From: Patel, Uday <Uday.Patel@lancashire.gov.uk>
Sent: 30 December 2014 12:06
To: planning
Cc: ENV LHS Customer Service
Subject: 3/2014/1089 - Proposed erection of 2 new dwellings and detached garage - Land off Clough Bank Lane Chatburn BB7 4AW

Planning Application No: 3/2014/1089

Proposal: Proposed erection of 2 new dwellings and detached garage

Location: Land off Clough Bank Lane Chatburn BB7 4AW

Project Proposed Dwelling to land behind The Manor House, Clough Bank Lane, Chatburn, For Mr and Mrs Harrison.		File Name 114-5	
Title PROPOSED SITE PLAN		Date 14/11/11	Drawn 247
Scale 1-250

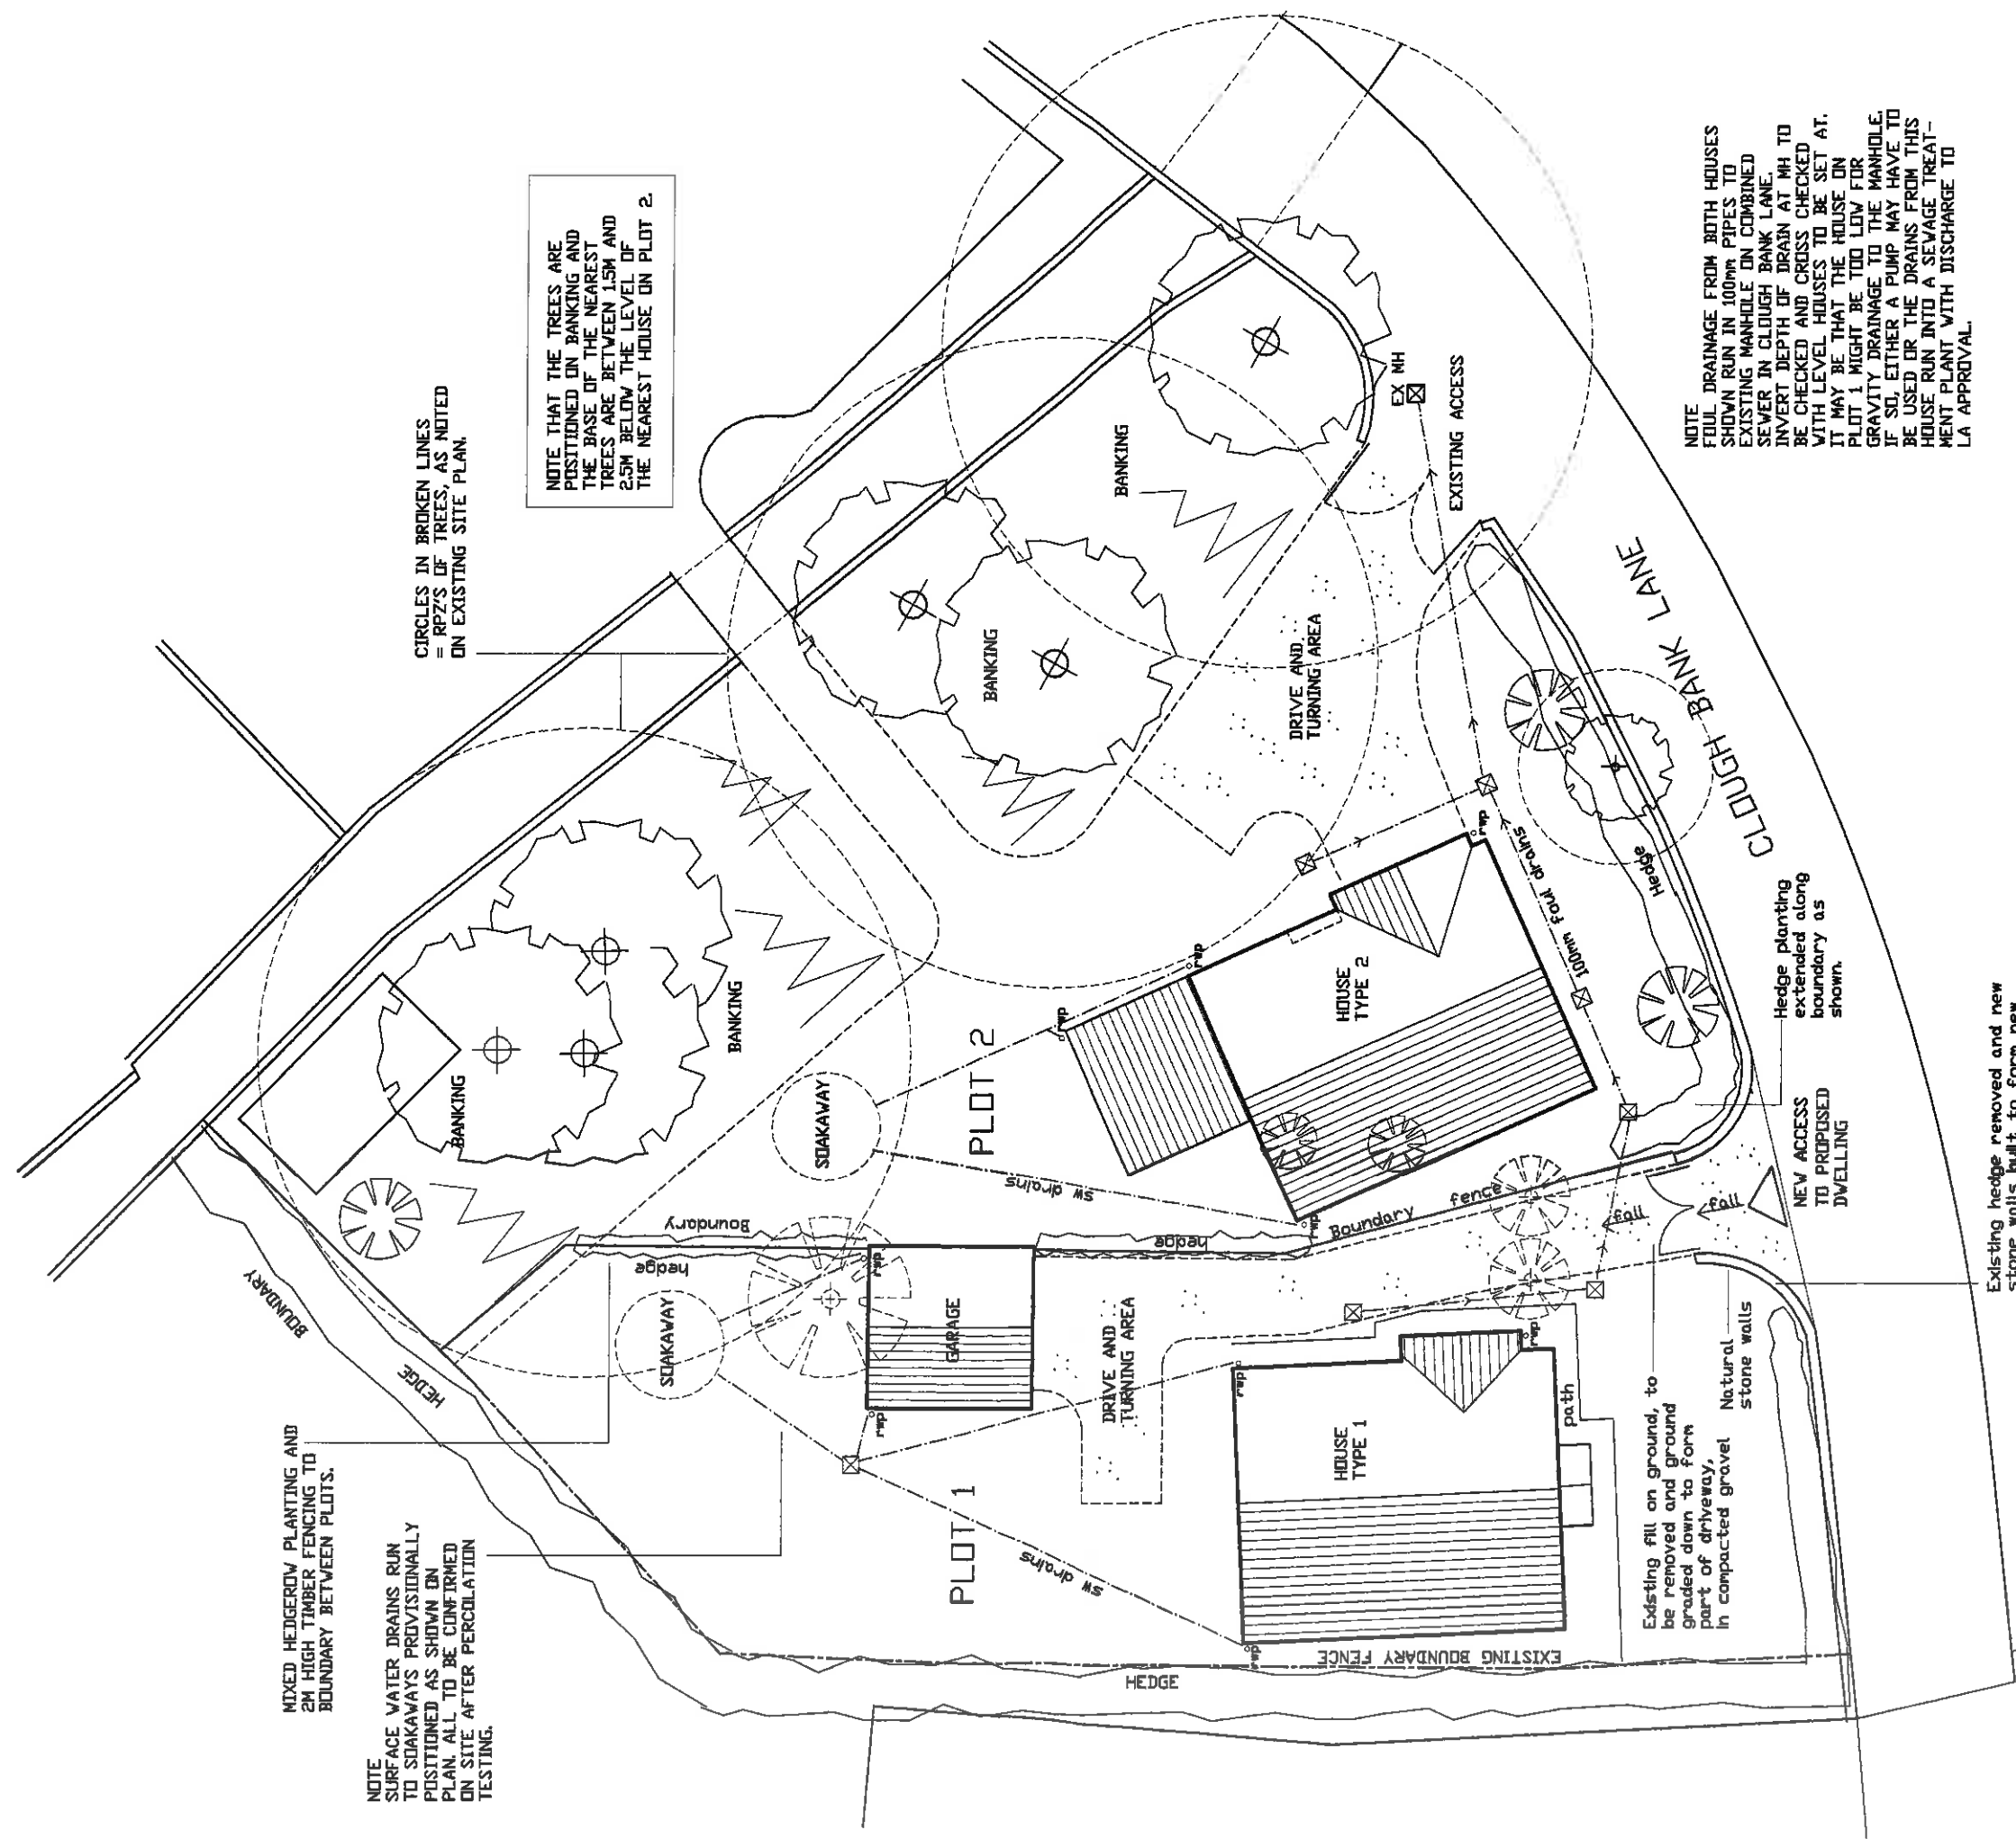
Due to lack of turning head at the end of Clough Bank lane there is a concern that how refuge vehicle will be able to access and manoeuvre to collect the refuge from the proposed development. It is believed that currently refuge vehicle is able to access the road to collect the refuge from other existing properties on the opposite side of proposed development along Clough Bank Lane.

There will be separate vehicular access from Clough Bank Lane to each of the properties. Geometry of the bell mouth access shall be acceptable to Highways Authority. There shall be 6m curve radius on either side of access and 4.5m clear width of the access.
